FIVE ESTUARIES OFFSHORE WIND FARM

Appendix H7 Natural England's Marine Mammal Advice on the Applicant's Deadline 5 Documents

Planning Inspectorate Reference EN010115

03 March 2025

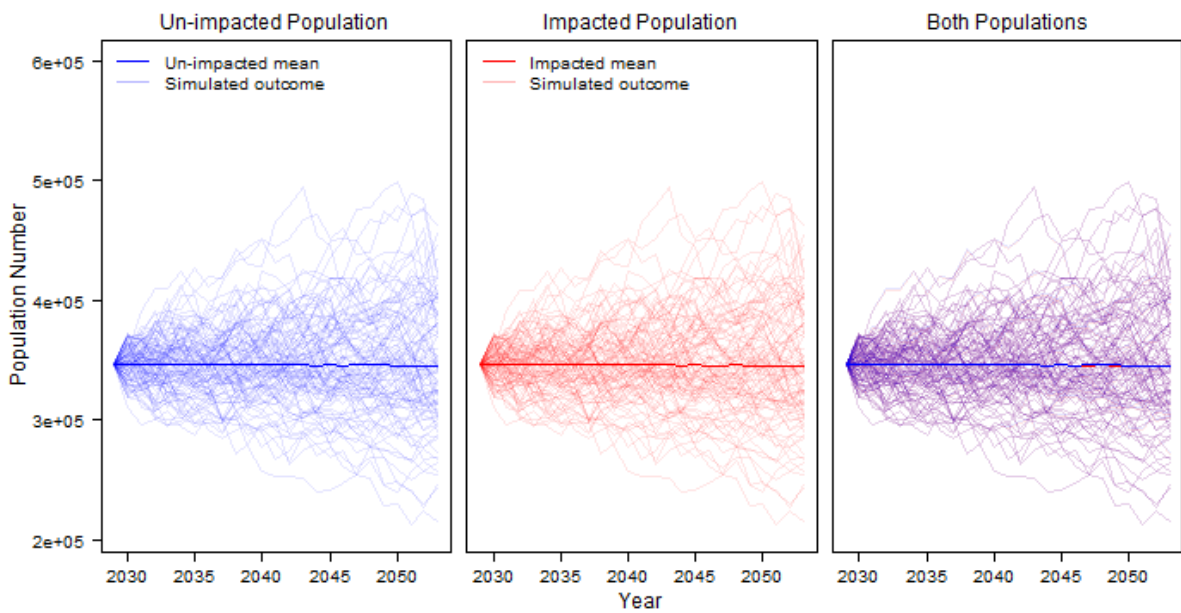
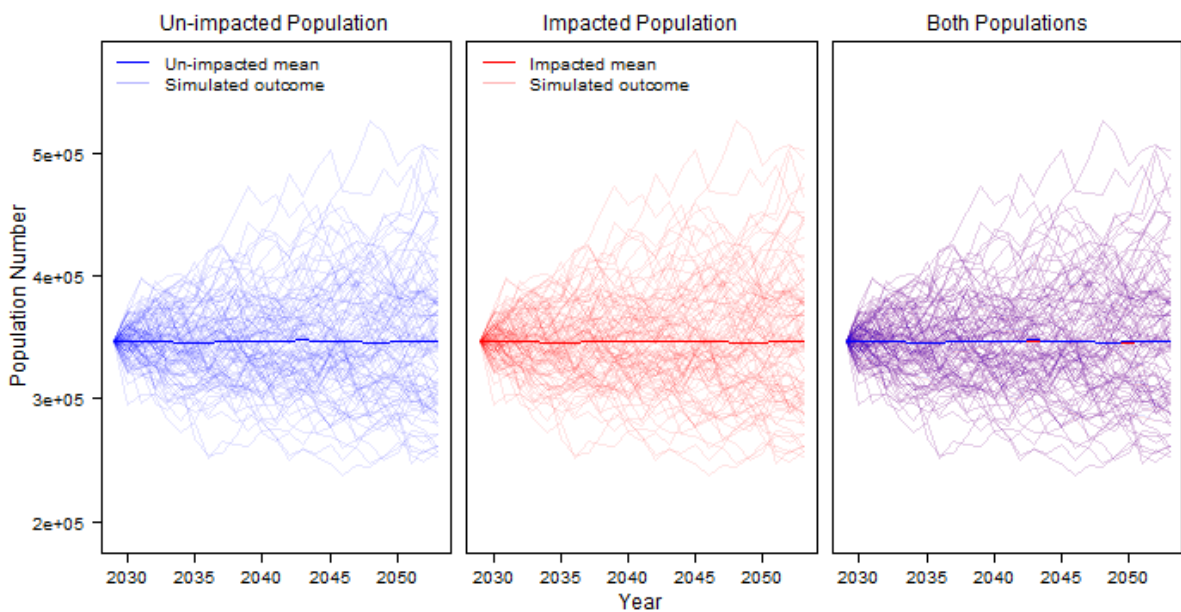
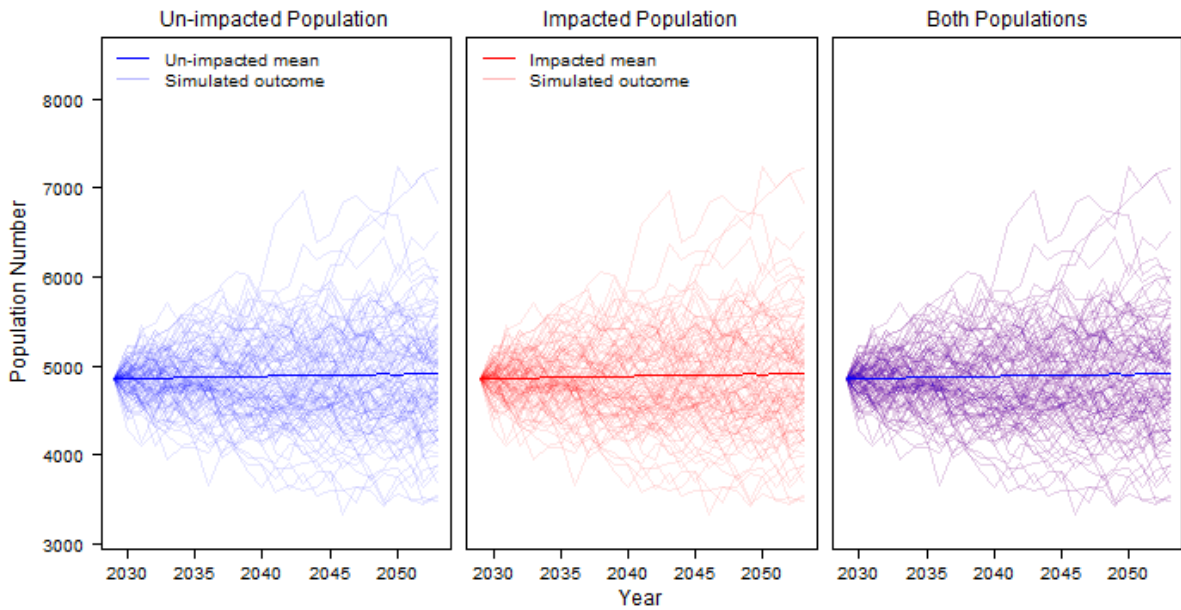
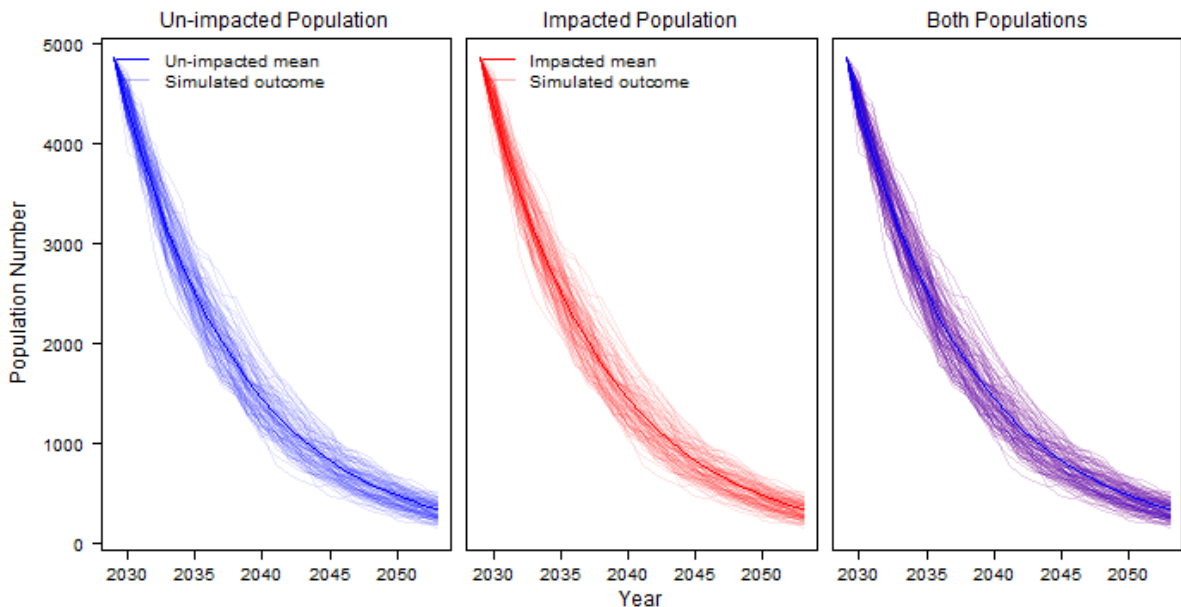
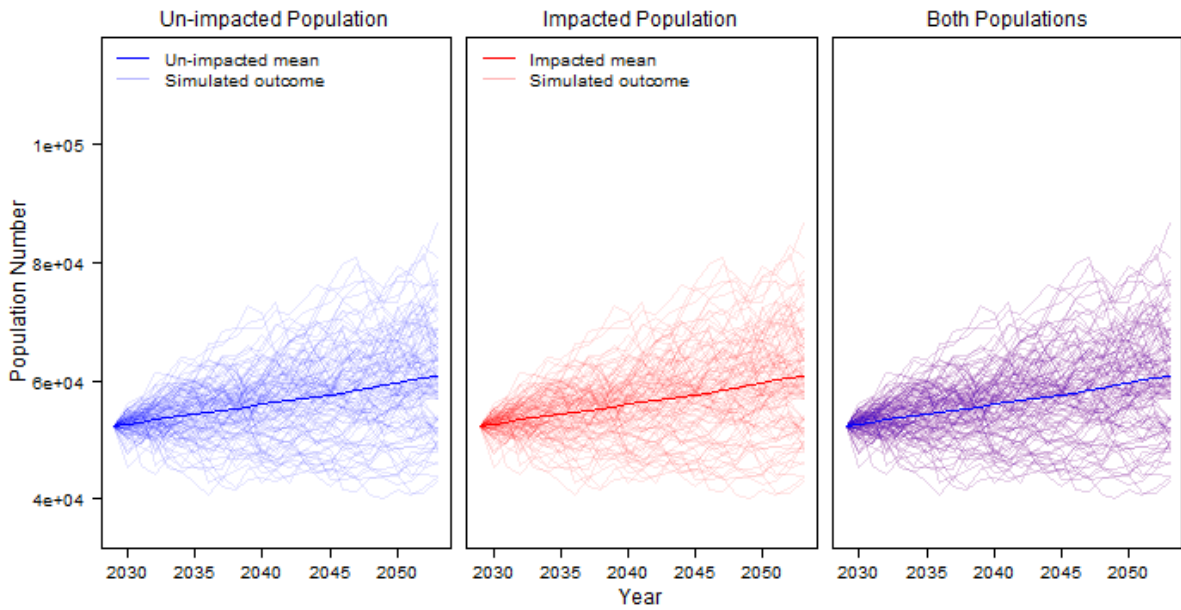
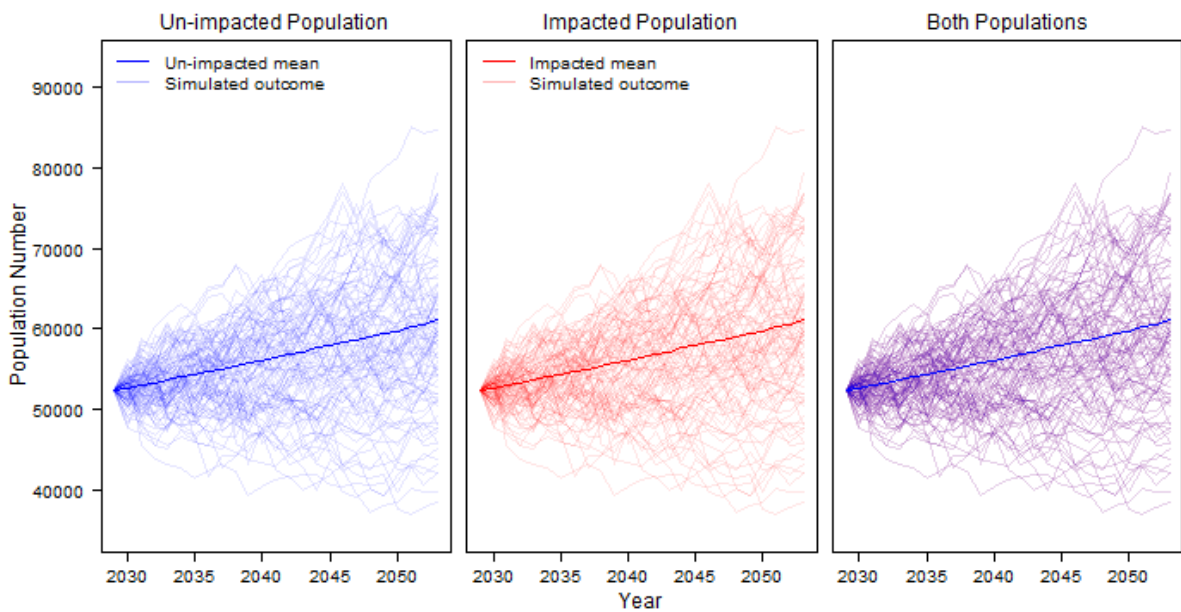
Document reviewed	Update made	Issue resolved? Yes/No/Progressed
[REP5-071] Five Estuaries 10.13 Marine Mammal iPCoD Modelling for Project alone - Revision B (Tracked)	<p>Natural England welcomes the inclusion of the median and 95% CIs to the iPCoD results tables.</p> <p>However, we note that there is no variation for median, mean and CI values for both species of seals between impacted and unimpacted populations (Tables 5.2.and 5.3). It is our understanding that the iPCoD model runs the simulations 1000 times for each scenario thus there is an expectation that the output values would show some variation. The outputs could potentially be the same if the population size is large (please note, a slight variation is present in the modelling scenarios for harbour porpoise whose population is significantly larger than those of seals), however the starting population for harbour seals is small and even considering a declining population does not demonstrate any level of variation between the impacted and unimpacted populations.</p> <p>In light of this, we have concerns around the variability of the outputs for the project alone and we believe that there is value in undertaking in-combination iPCoD modelling which may indicate a greater level of variation and potential population level impacts warranting further investigation.</p>	Progressed
